Re: Submission to SSD-32766230 – Nos. 35-75 Harrington Street, The Rocks

We refer to State Significant Development Application No. SSD-32766230 which proposes the following works at Nos. 35-75 Harrington Street, The Rocks:

Submission to SSD-32766230

Sheet No.
DA-5002

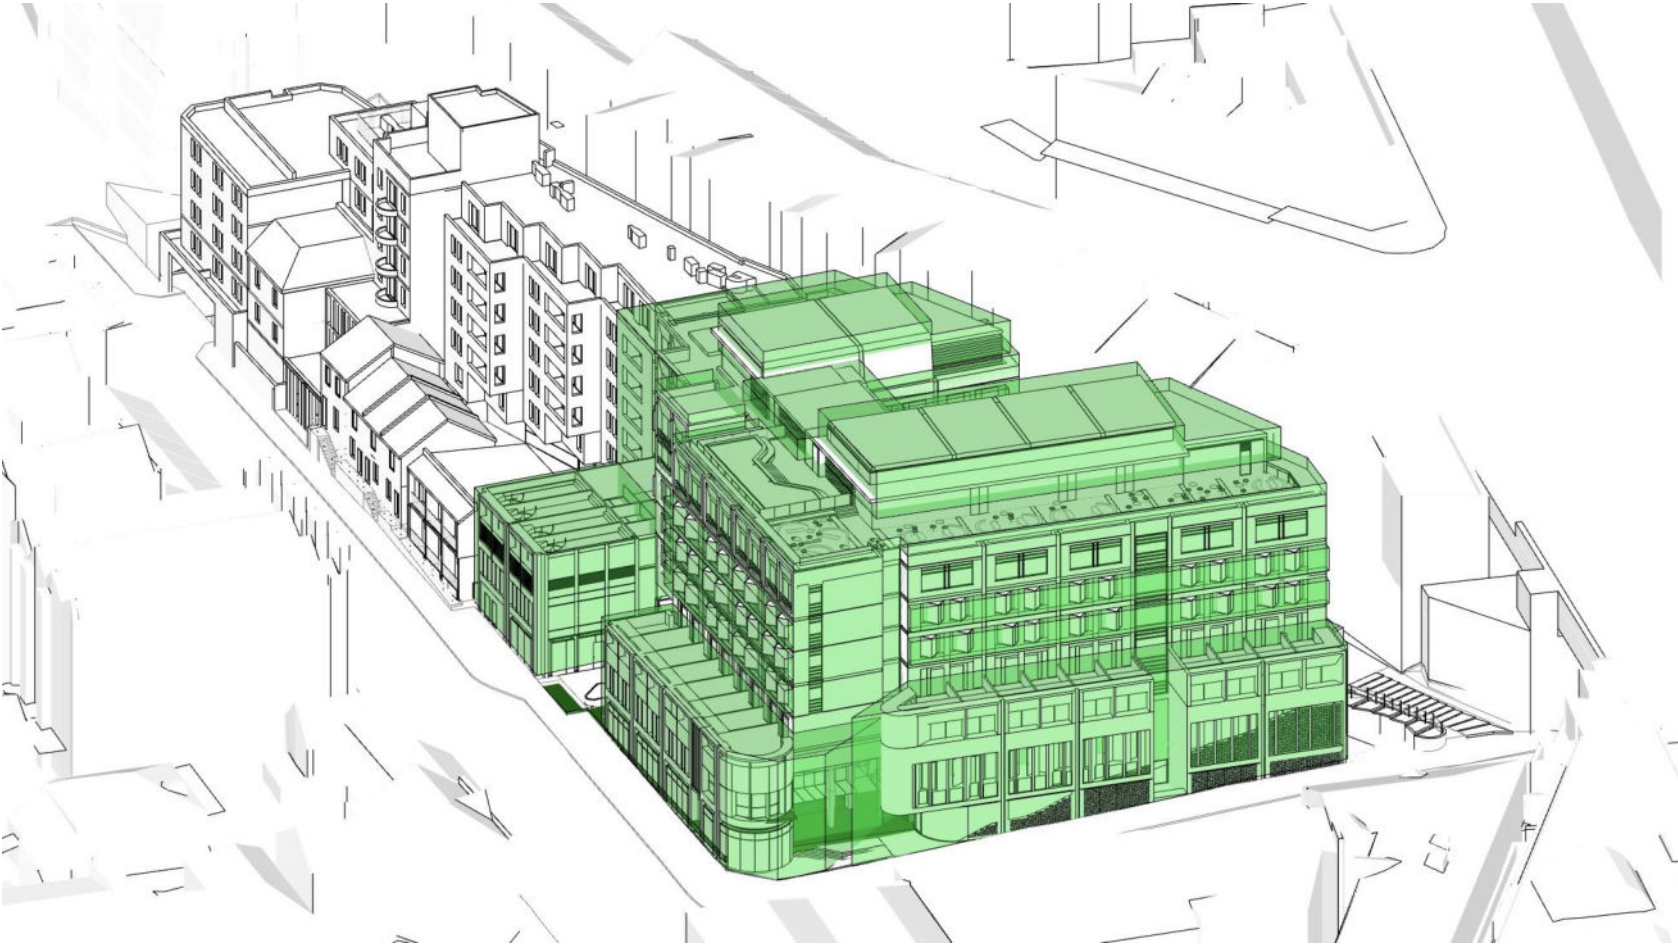
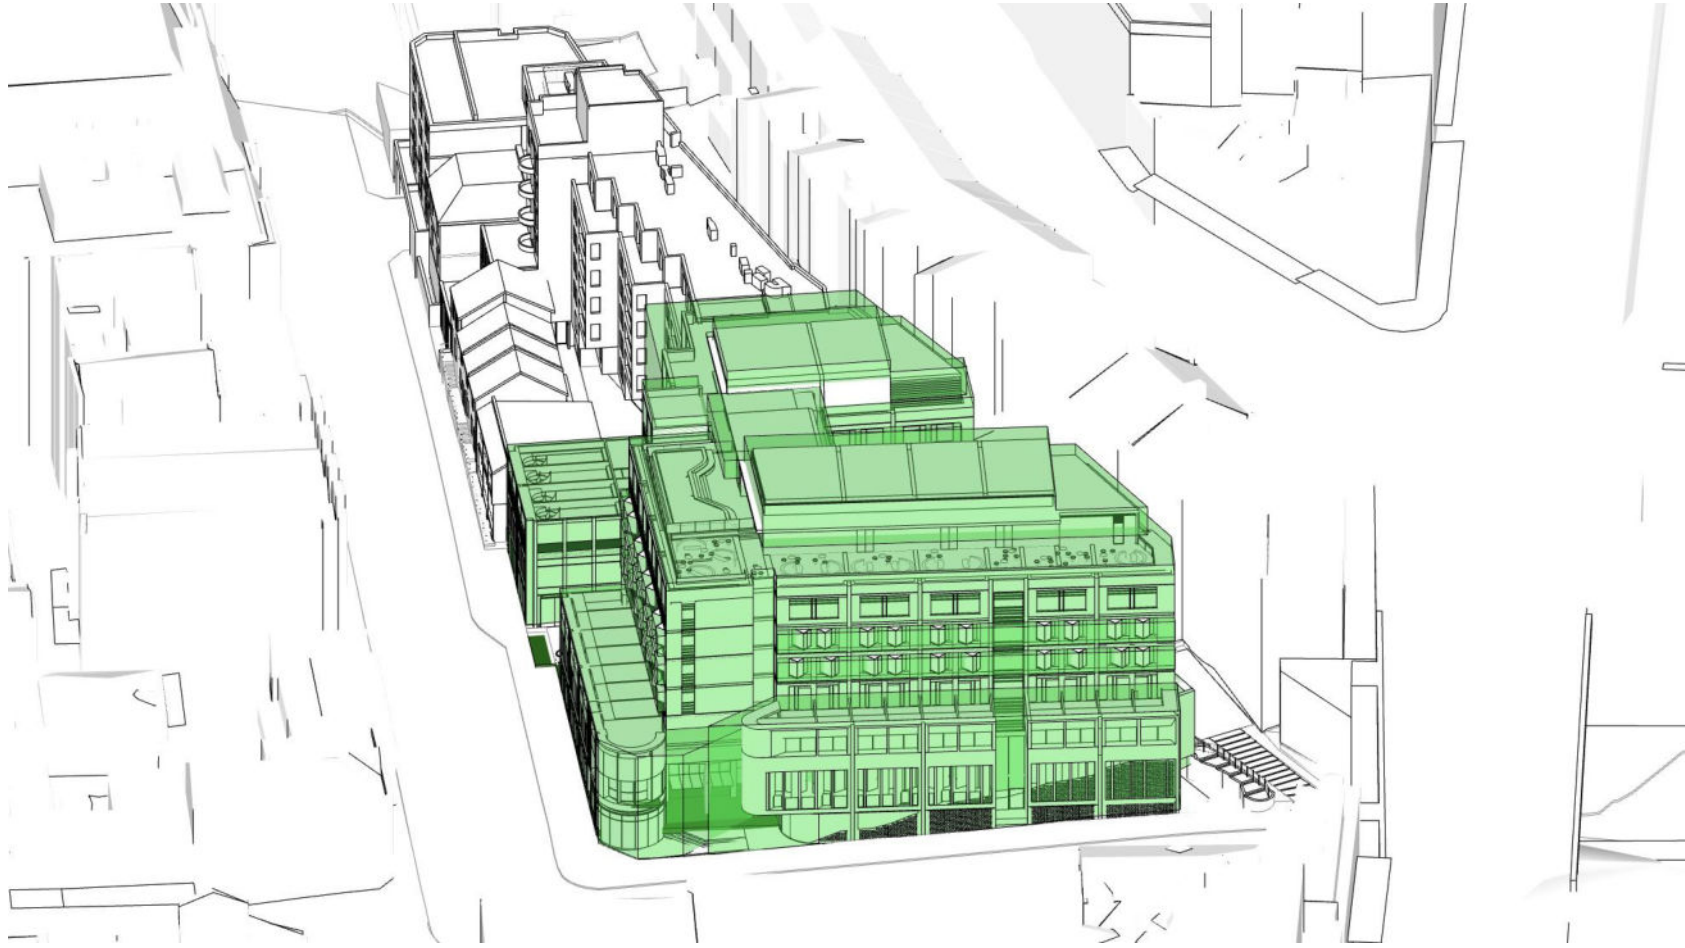
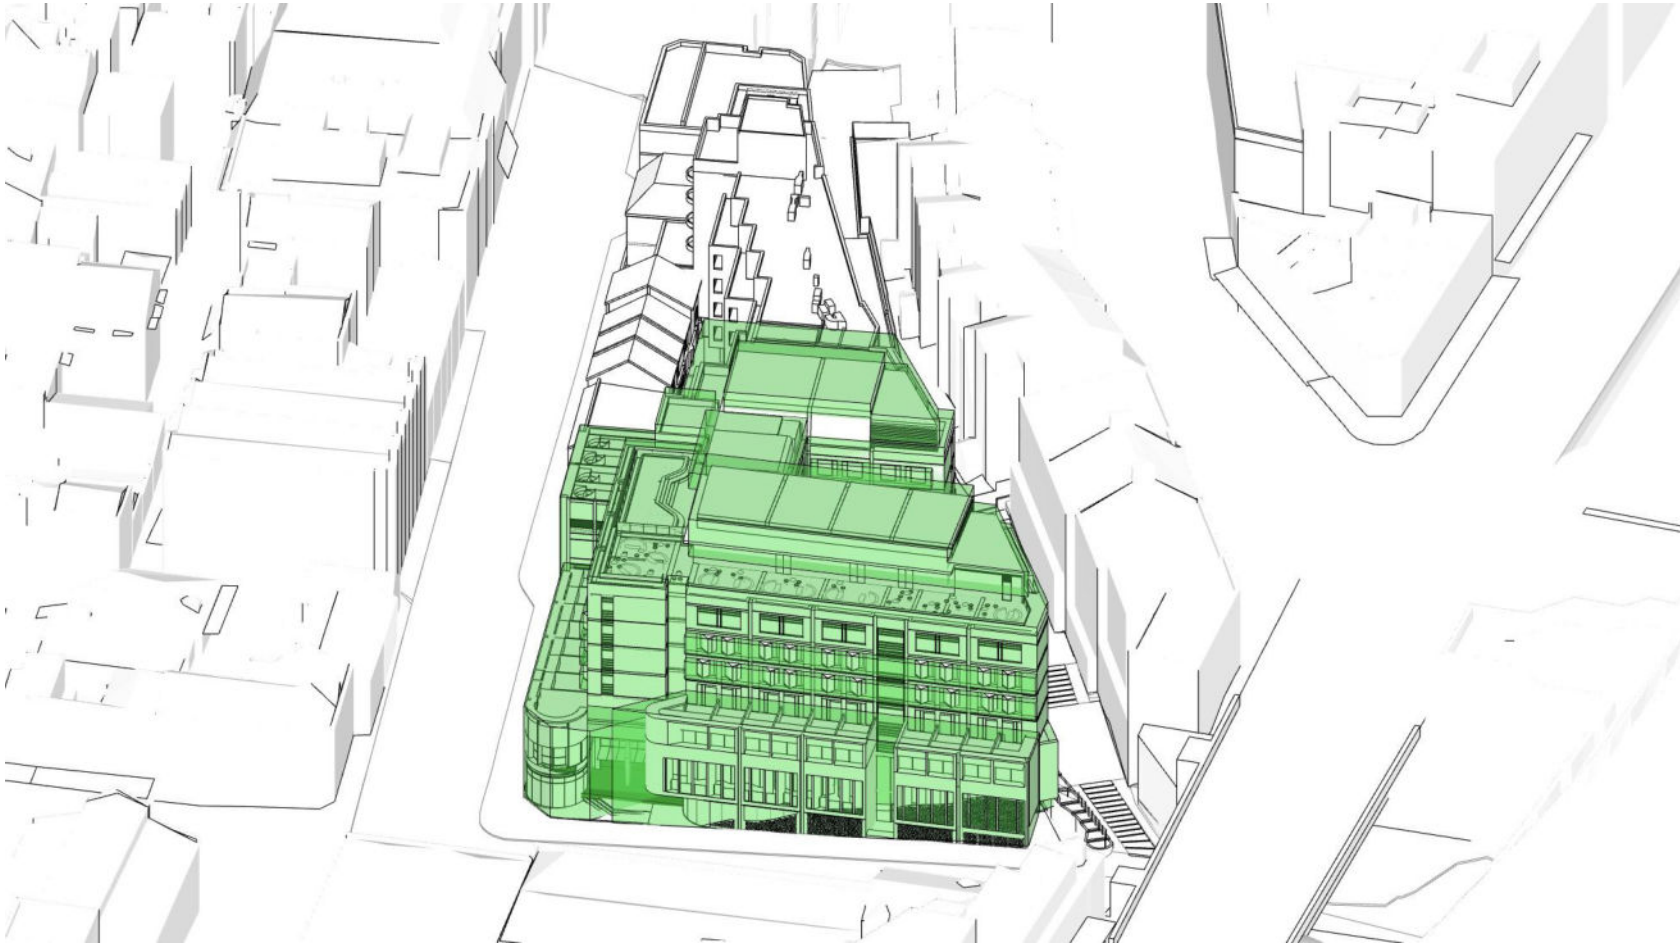
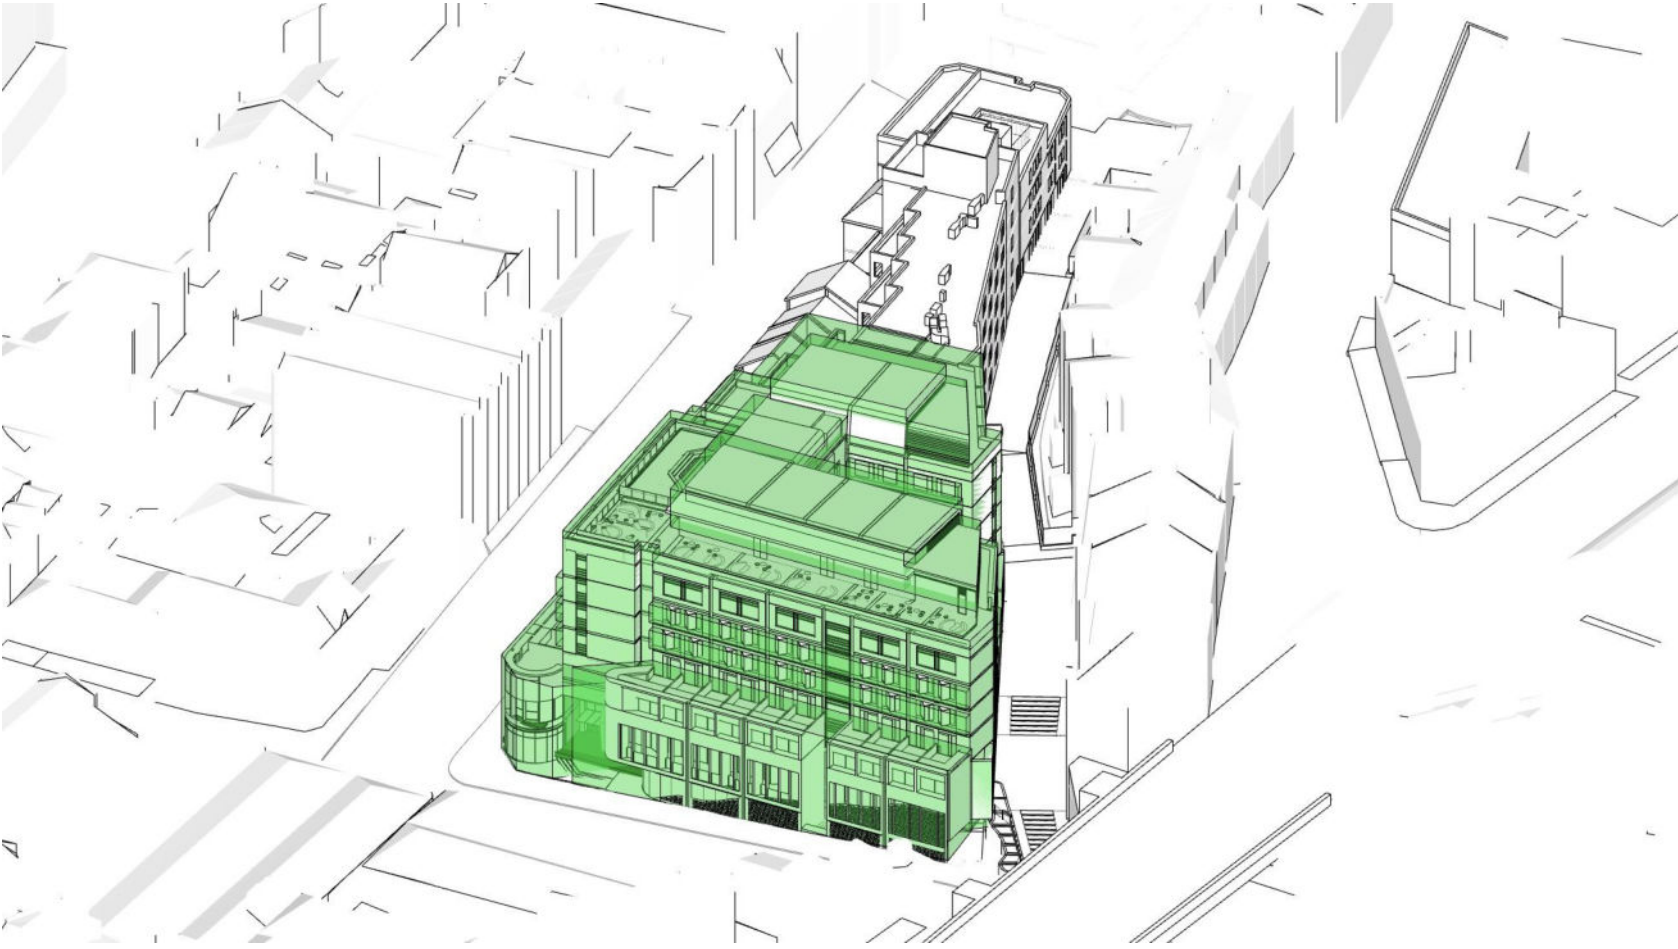
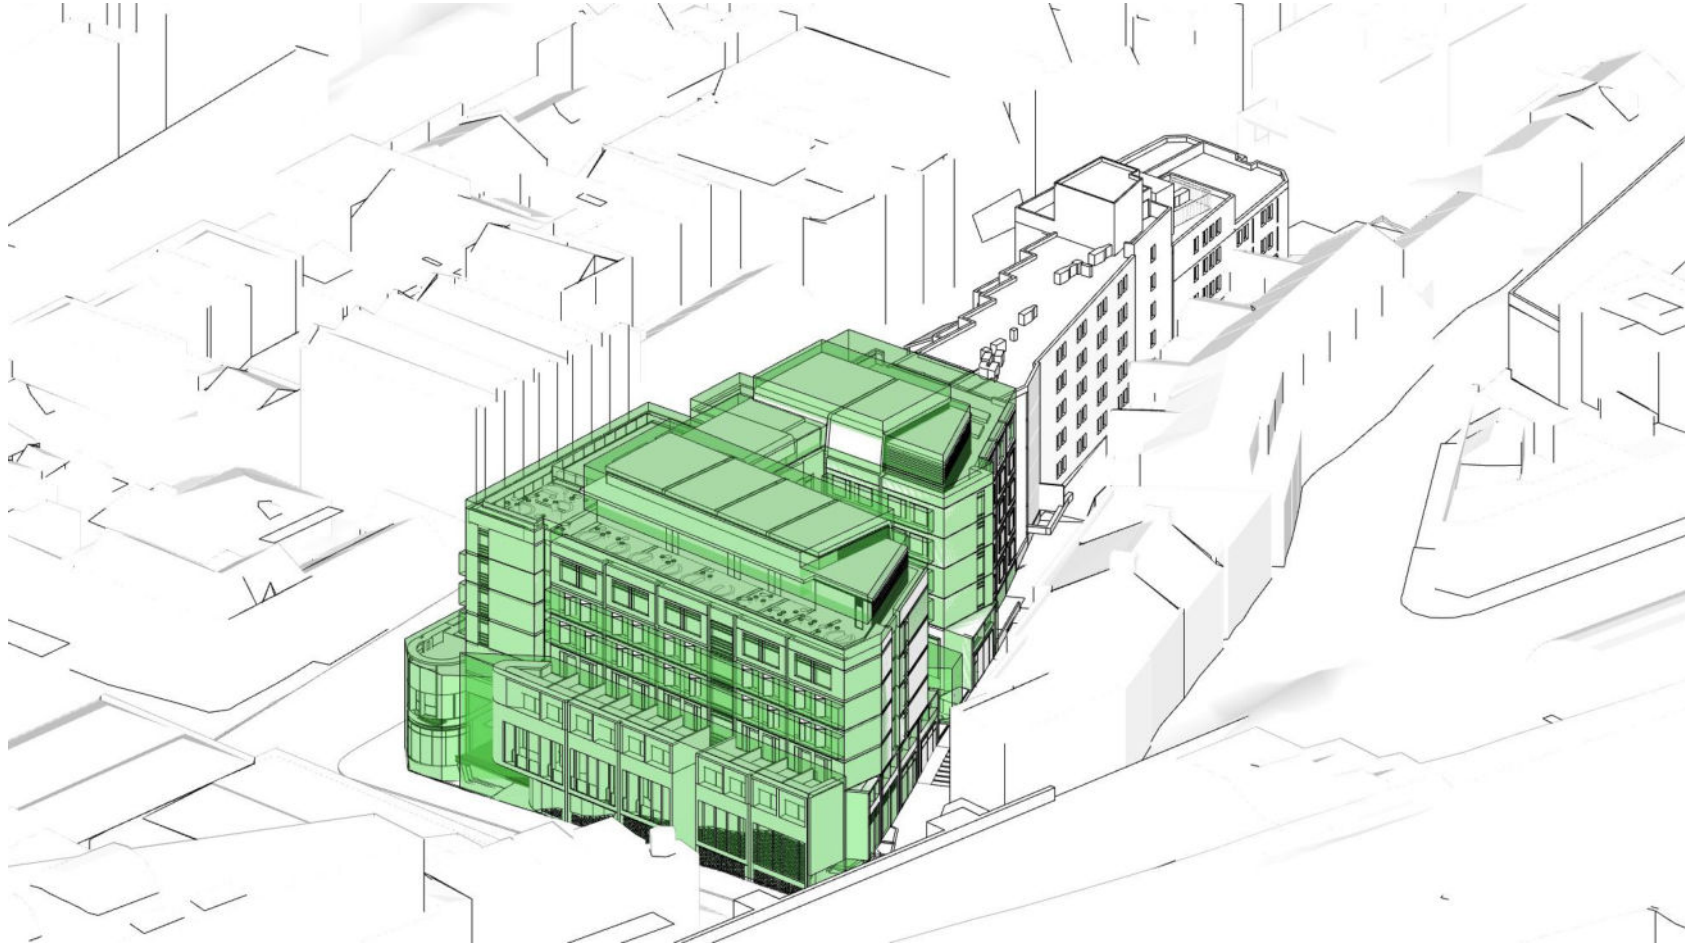
The increased in building height (i.e. +6.6m in the central and rear portions of the development site) will result in additional overshadowing impacts to the northern and western facades of No. 34-52 Harrington Street, between 2pm and 3pm (mid-winter and equinox) as noted in the applicants' shadow analysis documentation (see Figures 4 and 5 overleaf).

Whilst the proposed plans illustrate shadow impacts relative to the existing, approved SCRA scheme and proposed, the differential between such massing are ambiguous given the overlapping of colours.

Further, the shadow diagram plans have not been drawn to scale nor include detailed analysis of impacts to fenestration.

- Revised shadow diagrams are to be prepared to scale and clearly document shadow impacts to Nos. 34-52 Harrington Street (including existing fenestration).
- The shadow diagrams (in plan and elevation) are to be prepared at hourly intervals between 9am and 3pm (equinox and mid-winter) and clearly illustrate the following on separate sheets:
 1. Existing shadows.
 2. Shadows resulting from approved SCRA scheme.
 3. Proposed shadows.
 4. Cumulative impacts.
- Confirmation that the existing shadows impacts exclude the clock tower 'void'.
